**Land at Hay Green Lane, Birdwell Ref: 2020/0577**

**Revised Highway Works and Access Position Statement – 8.2.21**

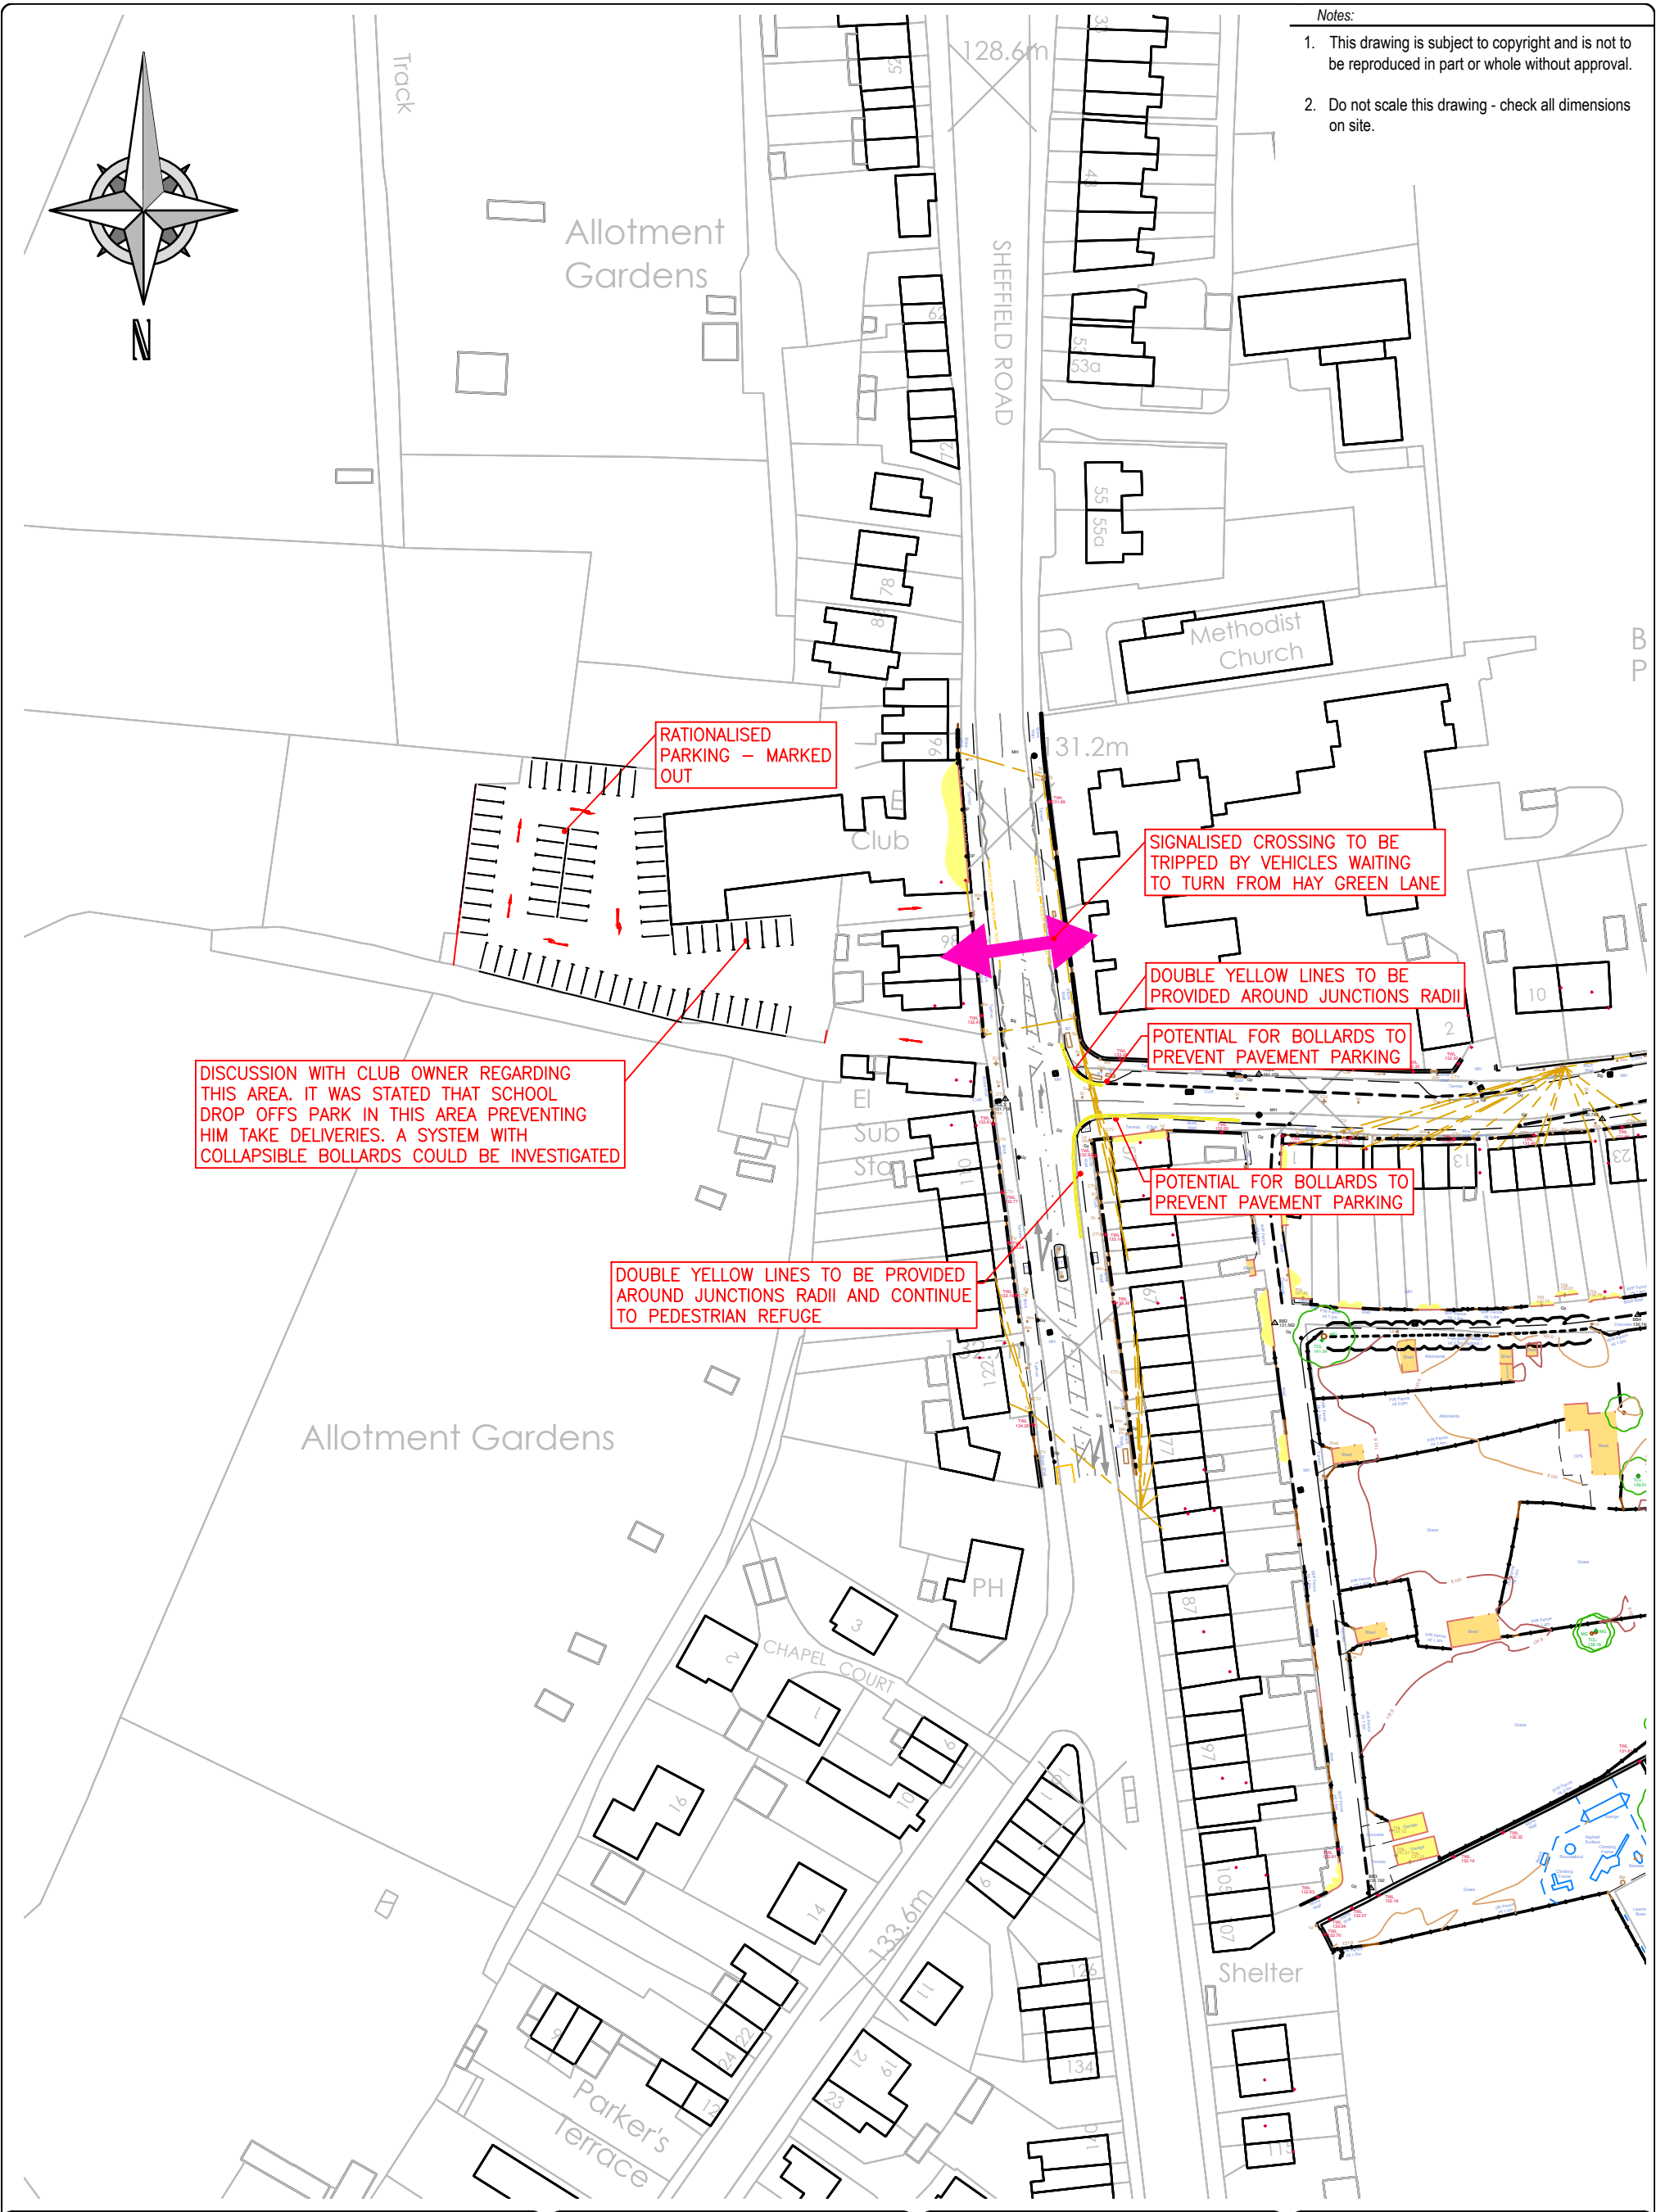
Implementation of the highways scheme shown on plan referenced Dwg. no. 18039.IN.08 Rev D to make improvements to junction safety:

- Bollards just past junction to Hay Green Lane/Sheffield Road junction to prevent parking (see plan referenced Dwg. no. 18039.IN.08 Rev D for location)
- White/yellow lining – (on junction radii and continued to pedestrian refuse - see plan referenced Dwg. no. 18039.IN.08 Rev D for location)

The above scheme is designed to reduce the impacts of the residential scheme upon the Hay Green Lane/Sheffield Rd junction and should go some way to reducing the impact of inconsiderate parking at the junction at peak times, including school drop-off, to ensure that visibility at the junction is maintained while also improving crossing capacity over Sheffield Road. Harworth Group are cognisant of the issues that local residents face in the area in respect of traffic and parking and have endeavoured to provide a scheme that not only mitigates the impact of the development but also goes beyond to improve the situation for local residents.
